RE: 3659/APP/2024/831 - 14 WESTBOURNE CLOSE HAYES

Subject: 3659/APP/2024/831 - 14 WESTBOURNE CLOSE HAYES

"Erection of a front dormer, following demolition of existing dormer."

LOFT PLAN (PRE-EXISTING)

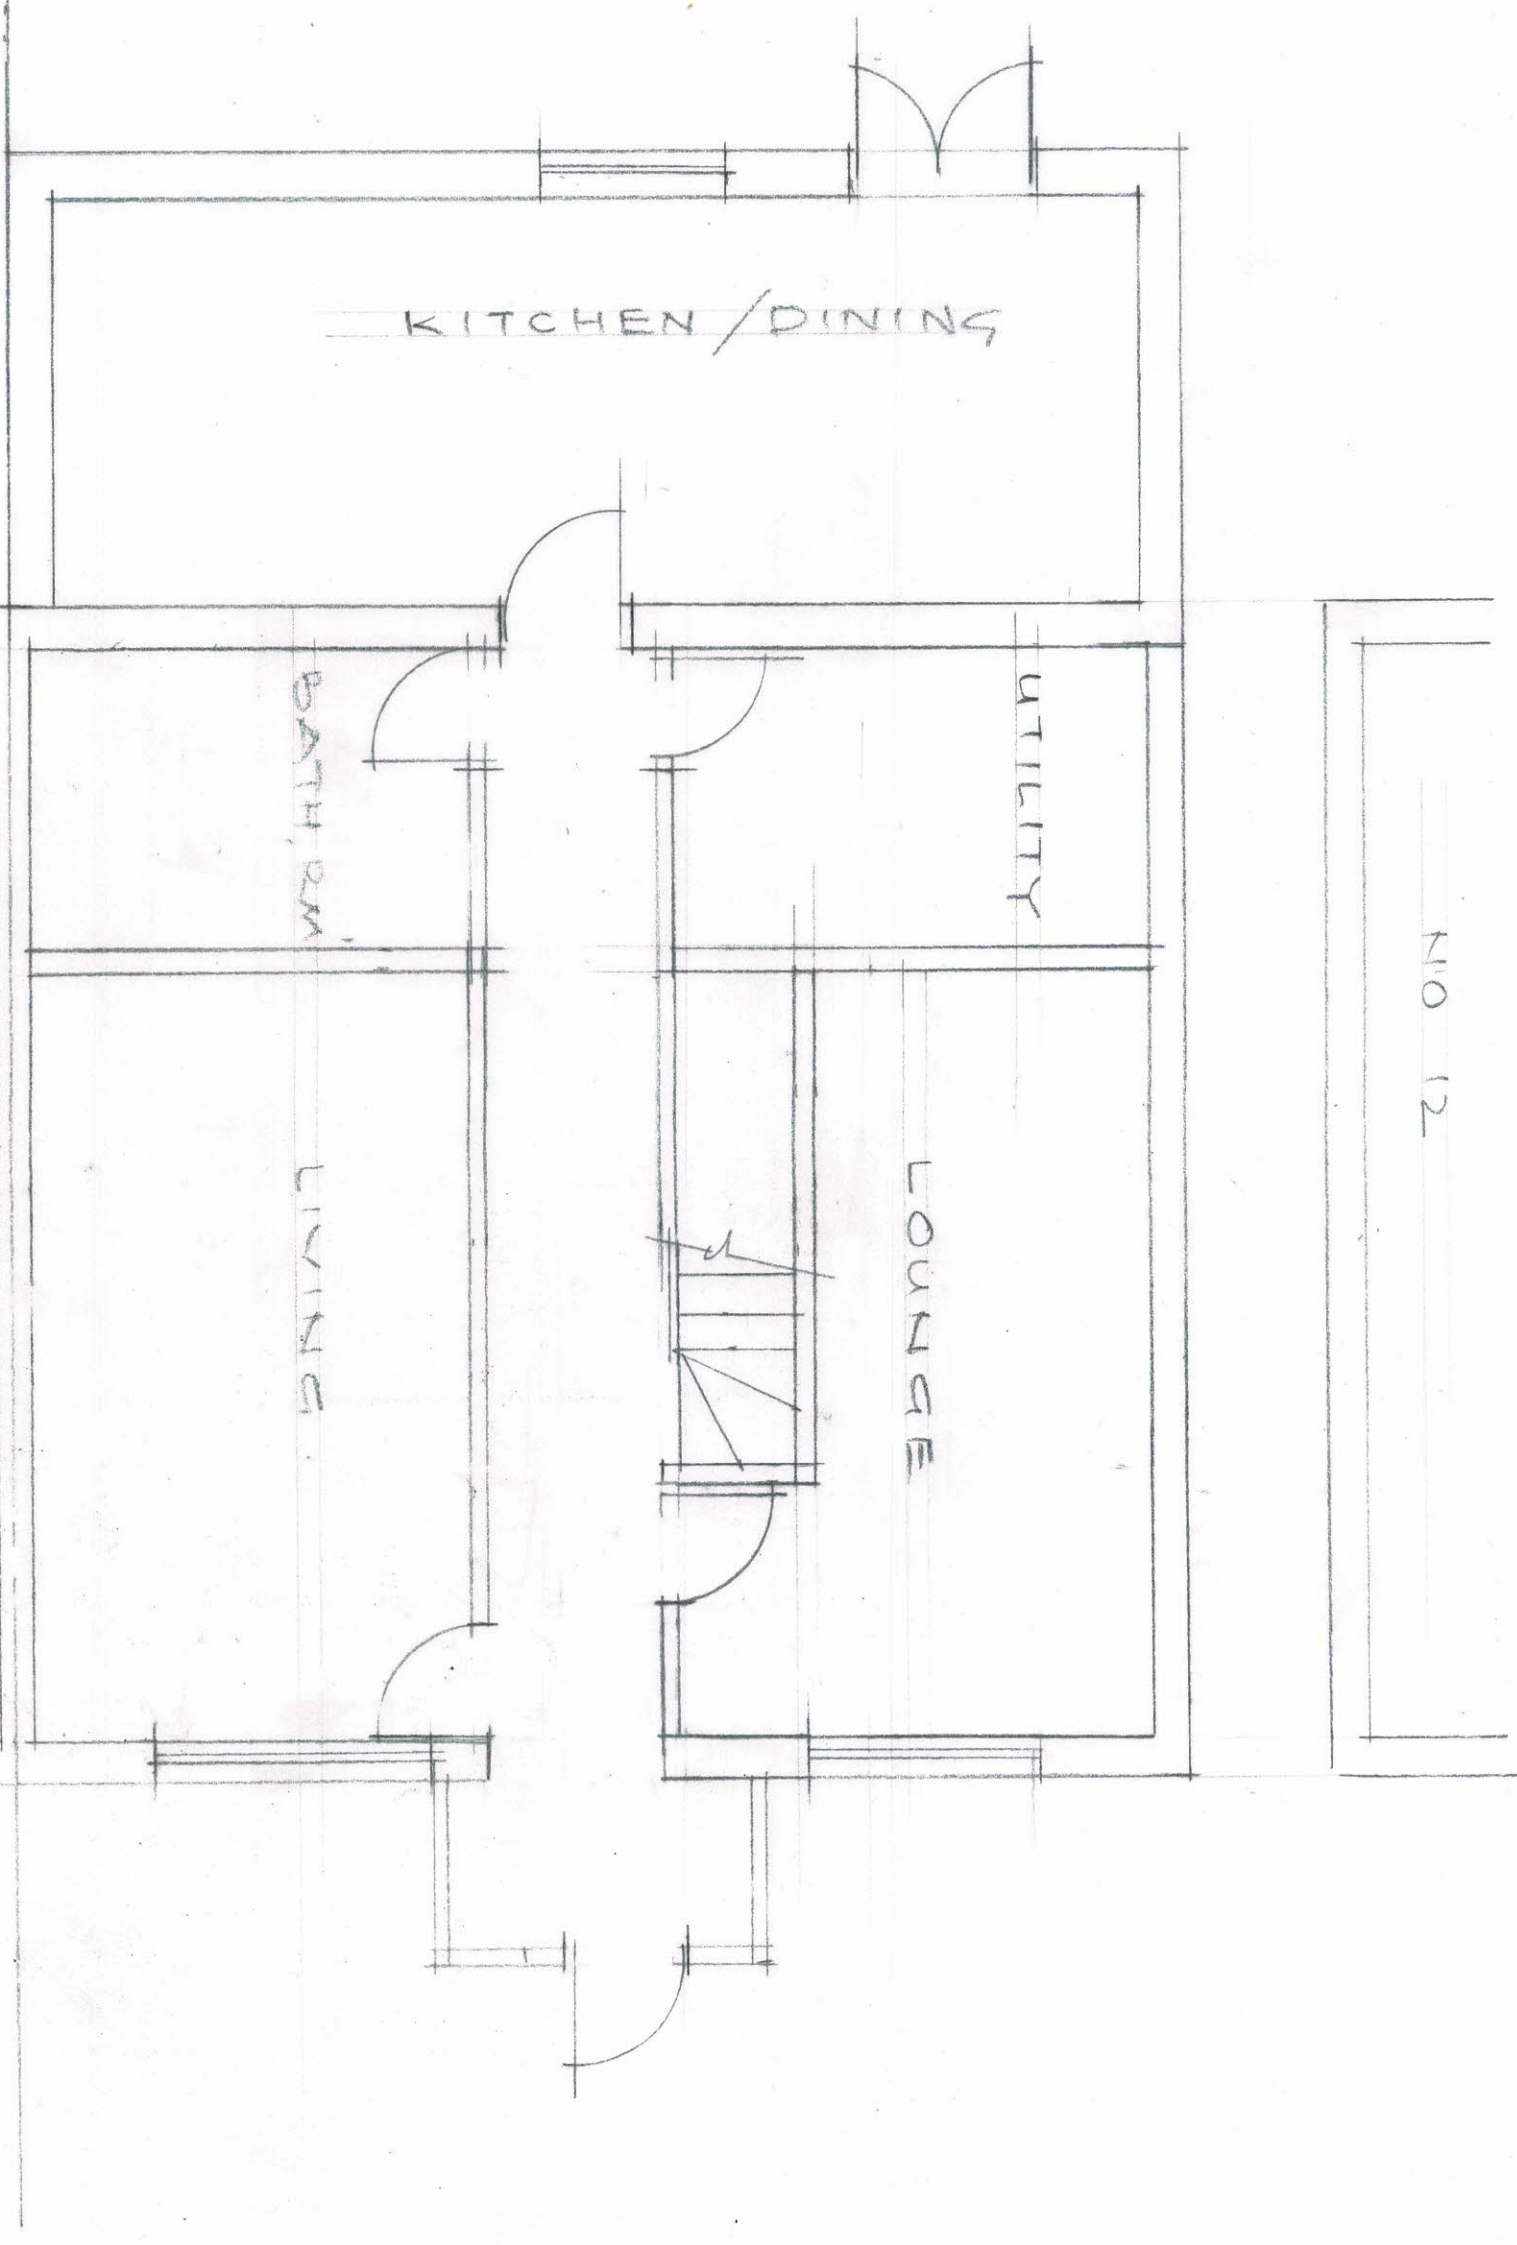
Amended plans would need to be submitted to show the original pre-front dormer construction as pre-existing.

Attached are the amended drawings as per your comments. Please note that ALL previous drawings sent with application will be superseded.
